September 24, 2013

**Re: 8801 Glendale Ave NE, Grading and Drainage Plan  
Engineer's Stamp Date 9-19-13 (B20D021)**

2 OF 2

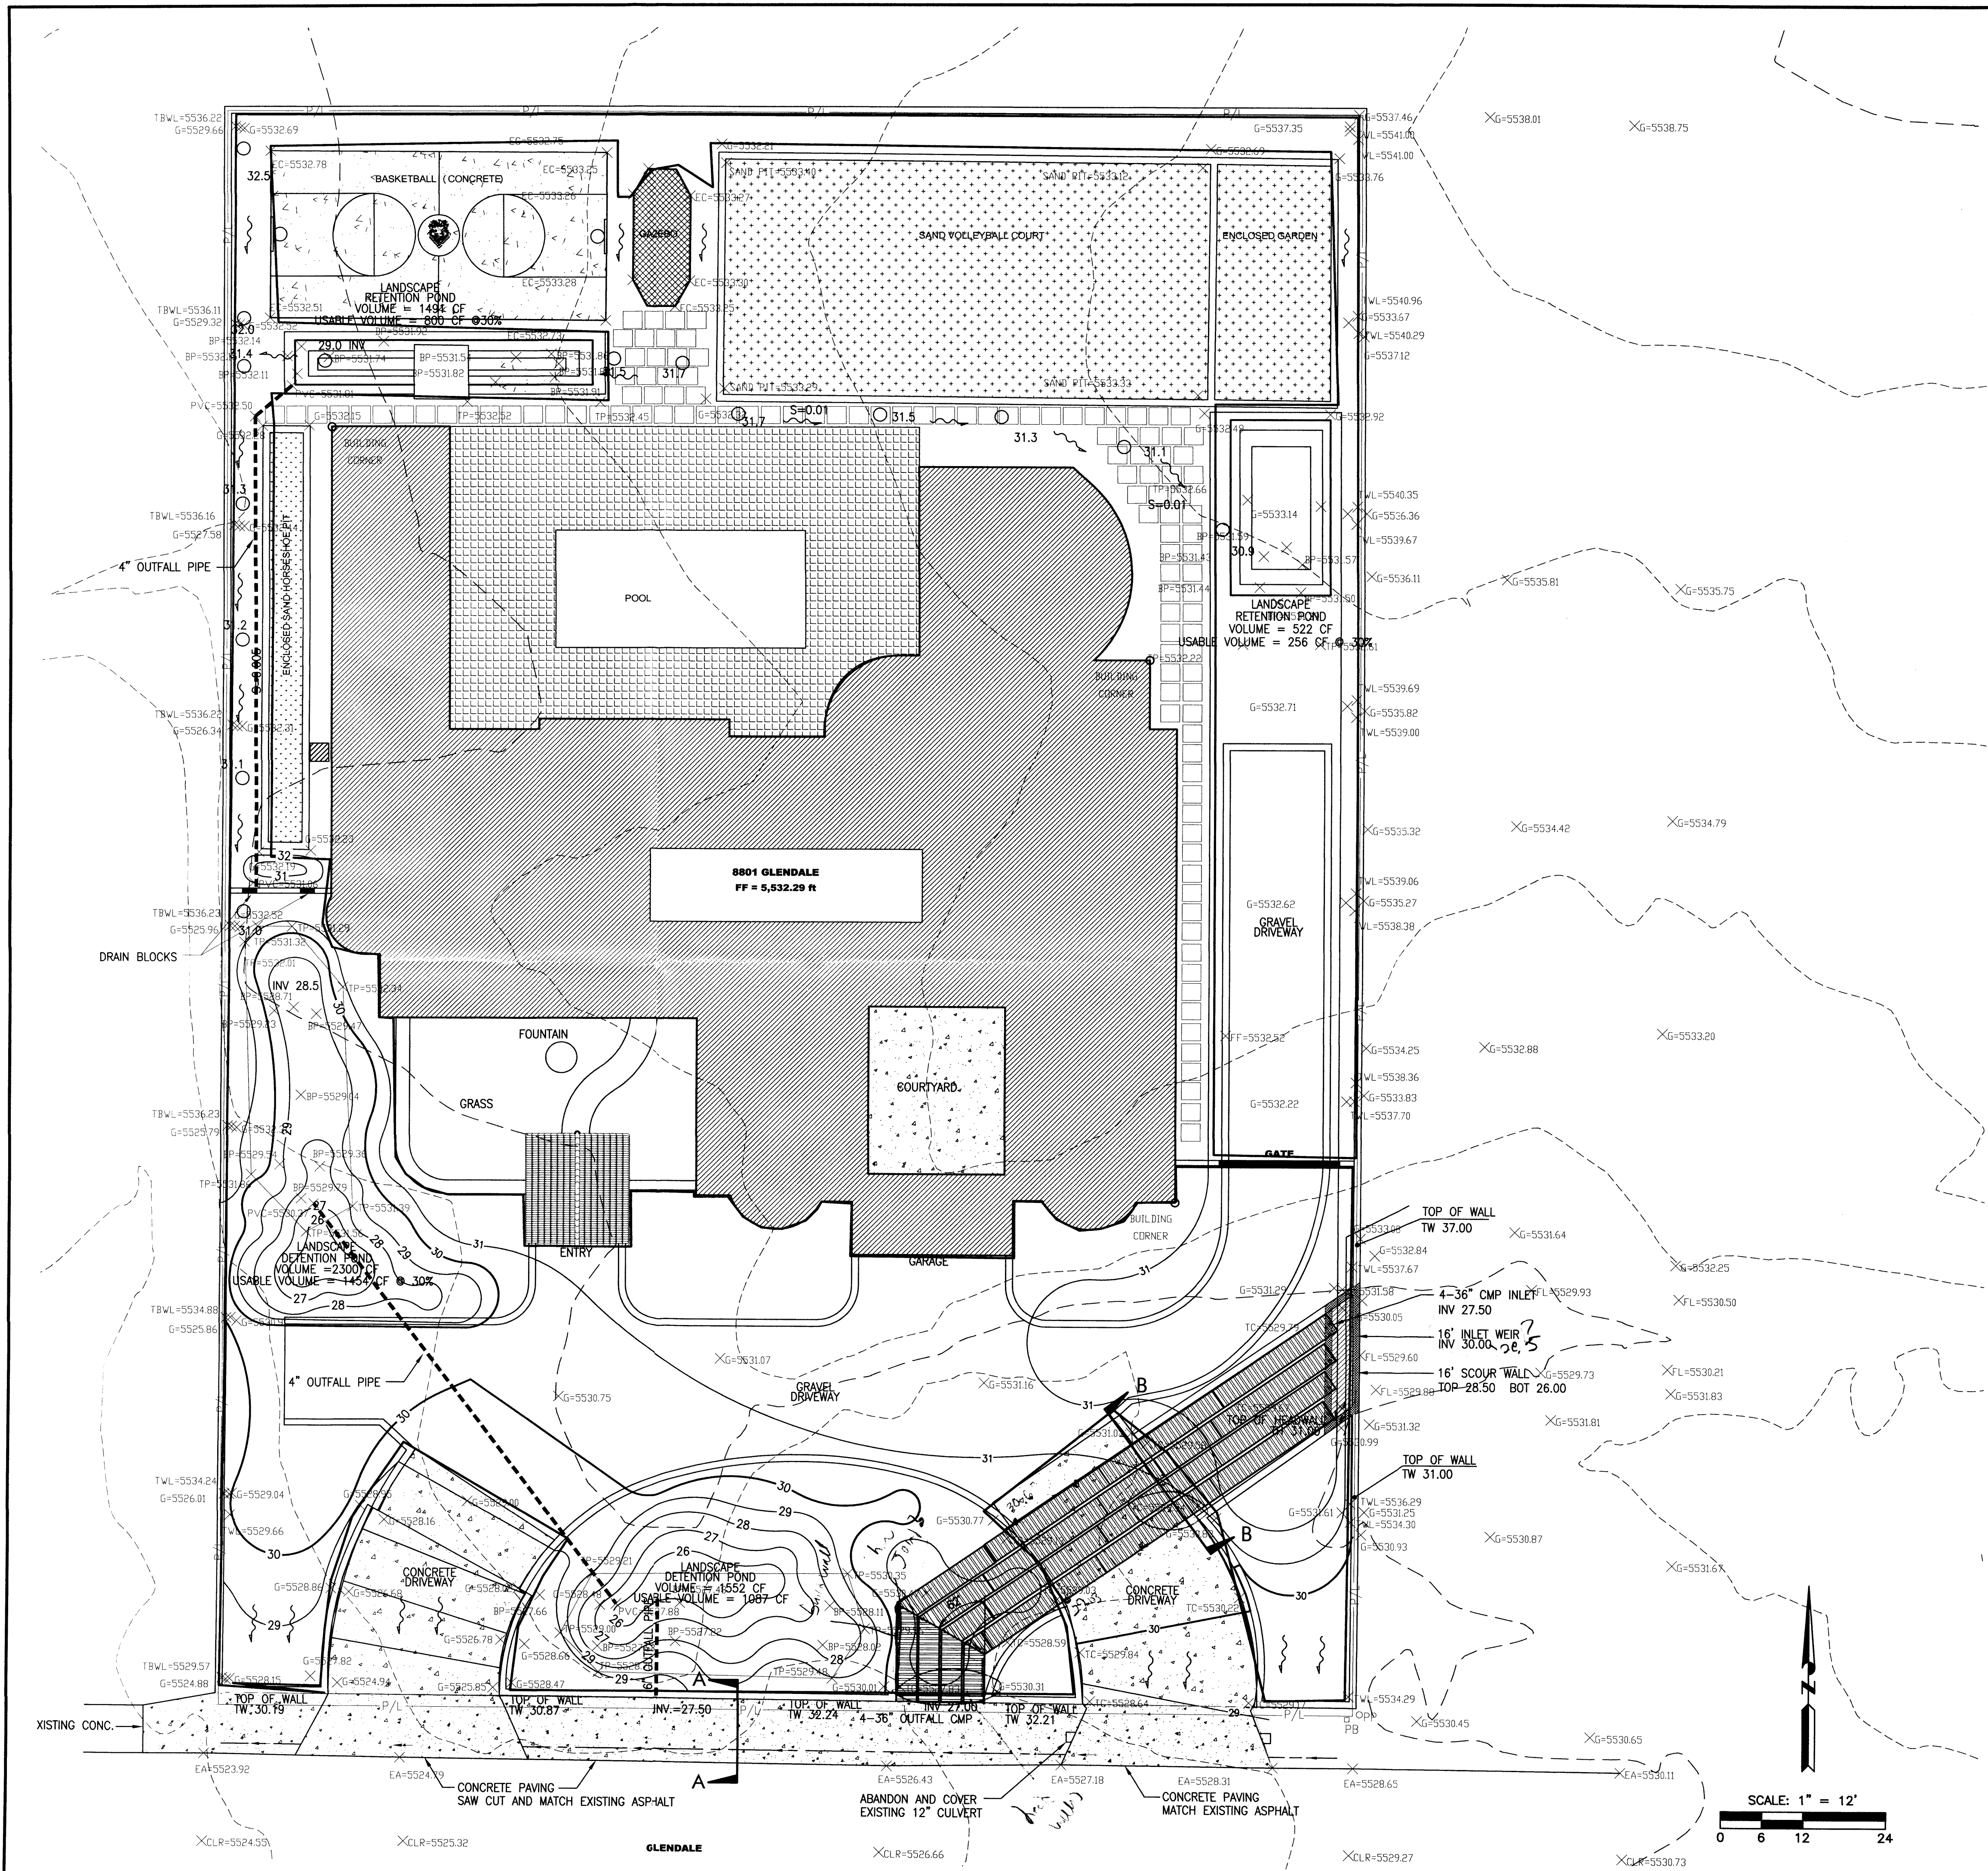
4. Add a build note to remove one course of block from the east wall south of the channel and along Glendale Blvd to the driveway.

5. Hydrology provides the following comments on the proposed concrete area between the edge of pavement and the wall.

A. The property owner wishes to keep the culvert under the east driveway. Show the culvert on the plan.

B. There is a telephone box where concrete paving is shown.

C. The flow line of this area should be near the middle of it. Similar to a valley gutter.

D. Provide a typical section of this area.

E. This concrete paving should tie into the 24 – 30” concrete paving on the west side of the property. A taper is recommended. Since this be built in front of the home to the west, the property owner is to discuss this with the property owner to the west.

F. The cut-off wall on the east side of the concrete paving along Glendale Blvd should respect existing grades somewhat.

G. Hydrology recommends a build note to saw cut the edge of pavement to facilitate pouring the concrete in this area.

6. Is there a hole in the wall, turn block or similar in the wall south of the horseshoe pit? Please show how flows leave this area.

7. What is the invert of the 6” outfall pipe on Glendale Ave?

8. What does the faint line south of the wall indicate?

9. Show the property line on the plan.

10. a 1:12 scale is very difficult to use and not an approved scale in the DPM. Please adjust to a 1:10 or 1:20.

11. The soil east of this property near the arroyo should have a maximum slope of 3:1. Property owner approval of the east property is required. This approval does not have to be submitted to Hydrology.

12. The large dirt pile on the lot to the east is to be removed and this area restored to predevelopment grades.

CULVERT INLET DETAIL

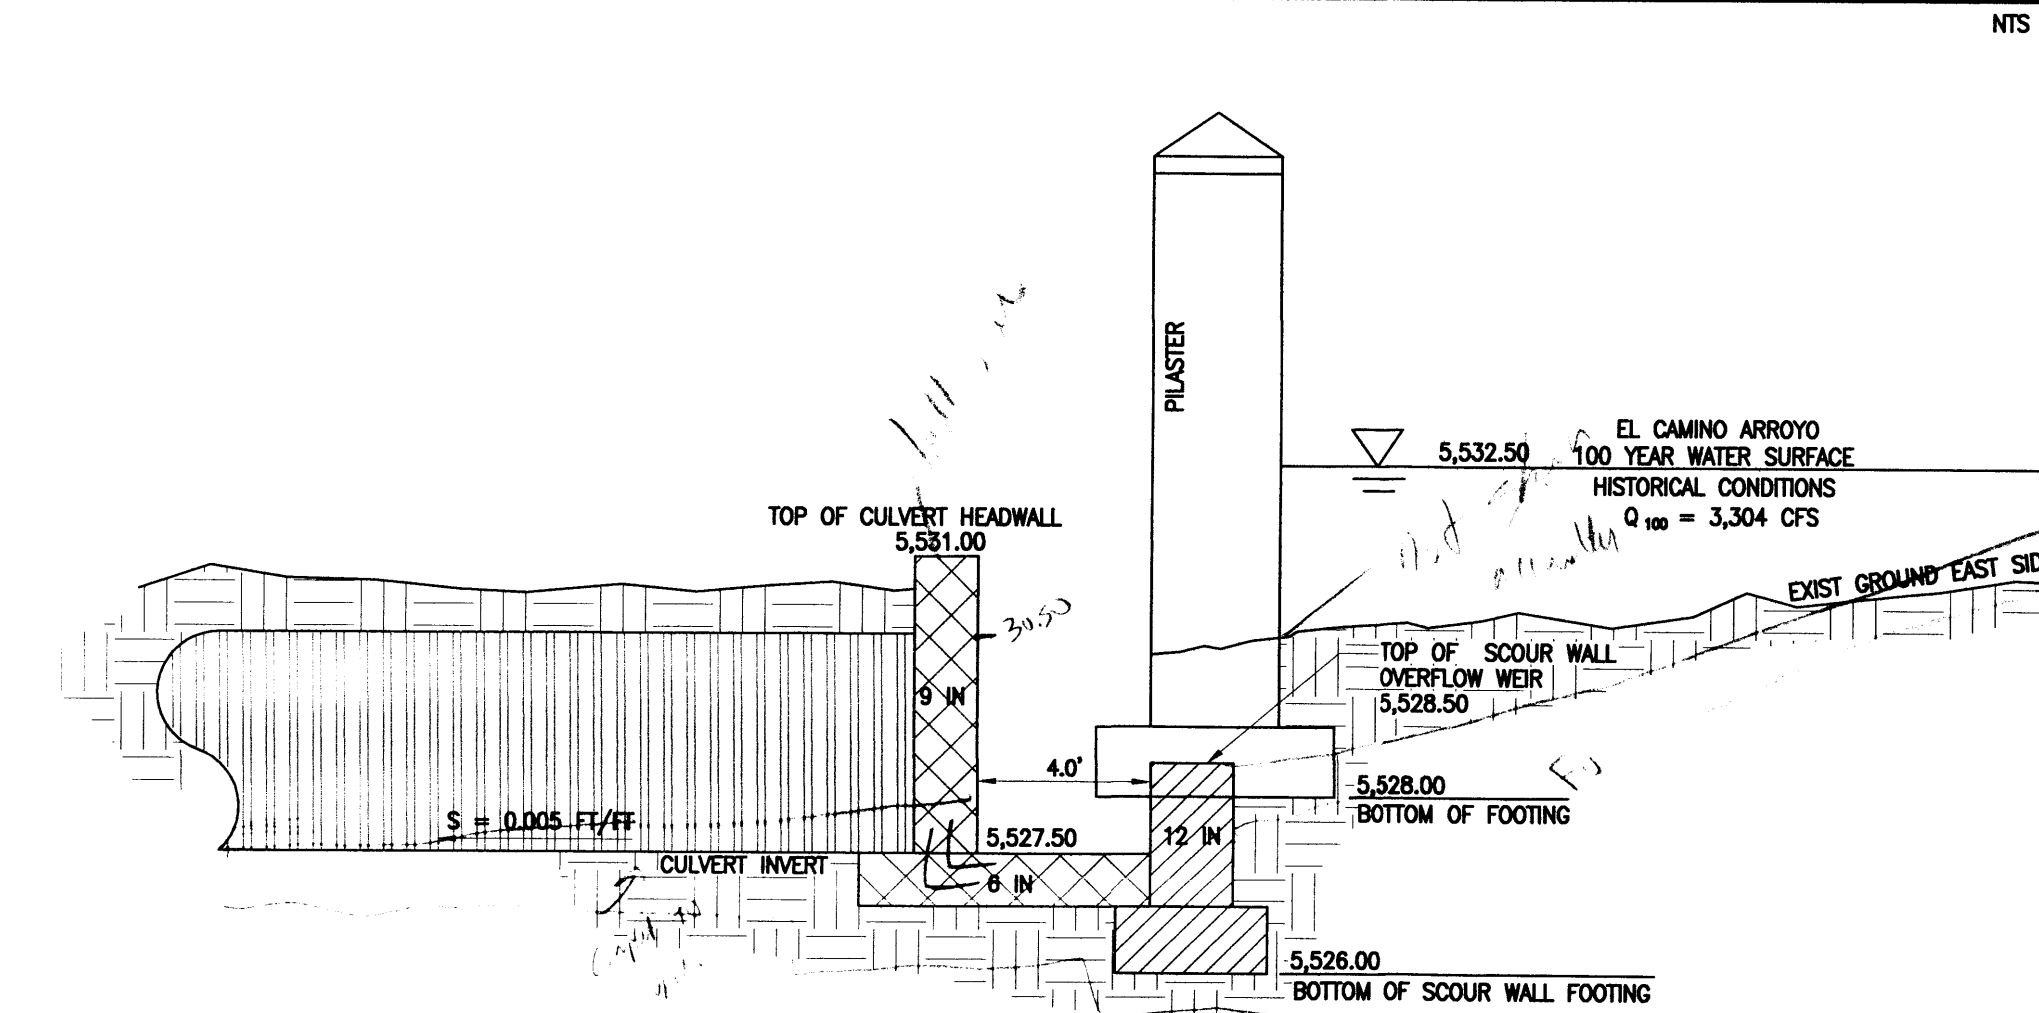
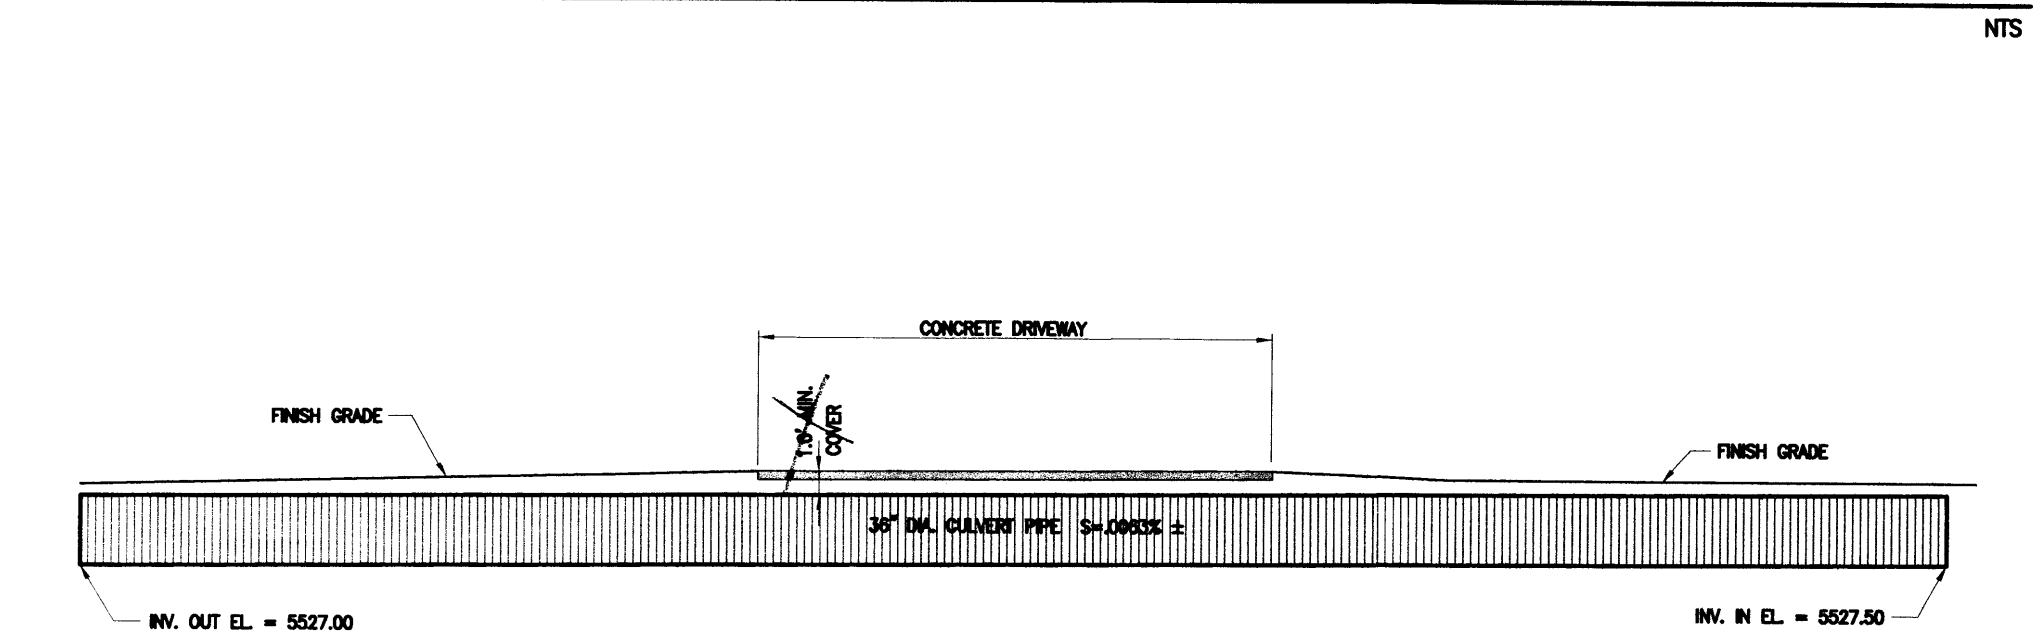
1. Per a site visit on 9-23-13, the invert of the channel is approximately 5527.5, assuming the elevation of the bottom of the footer on sheet 2 of 2 is correct. This elevation may have dropped from the existing grade shown on the approved grading and drainage plan of 5528.64, Thames Engineering and Design stamp date 9-1-11.

A. The "Exist Ground East Side" elevation should be changed to reflect the current existing condition, which is approximately at 5527.5. The top of the scour wall elevation should be set at 5527.5.

B. It appears the sump inlet will may not be required.

C. Include the benchmark used for the topographic survey. The previous monument used was "7-B20", which was confirmed as NAVD88.

D. The footer(s) of the wall may require protection.

2. Provide a build note for the concrete slab underneath the pipes. Should this be a monolithic pour with the scour wall?

DRIVEWAY CULVERT SECTION B-B

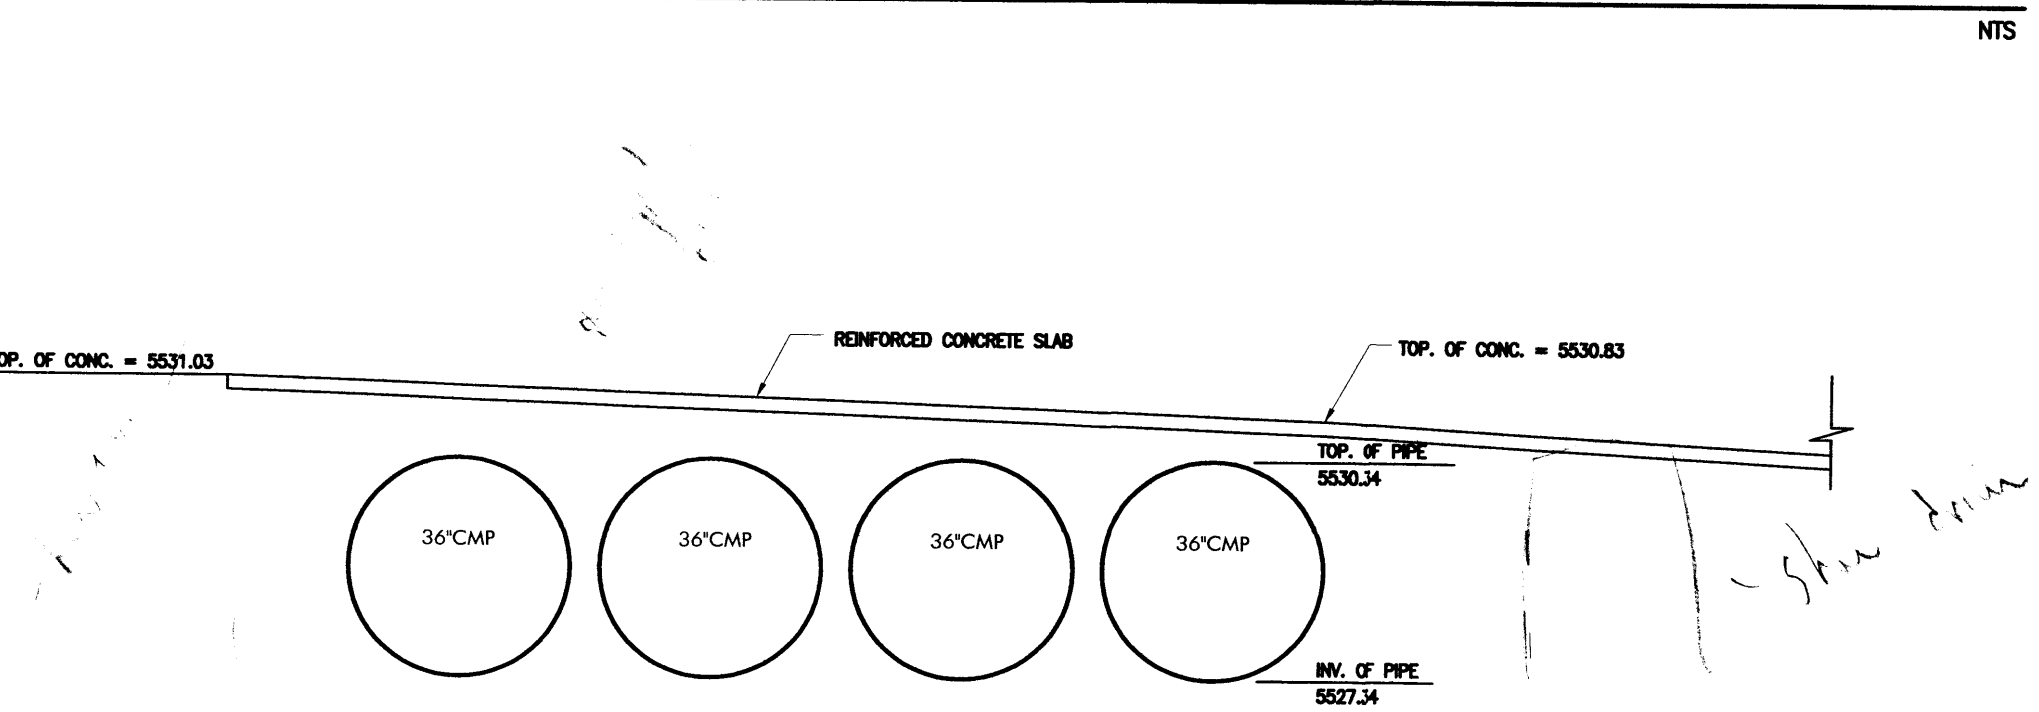
3. Provide a section through the storm drain in the driveway. A minimum of 12" of cover is recommended for CMP.
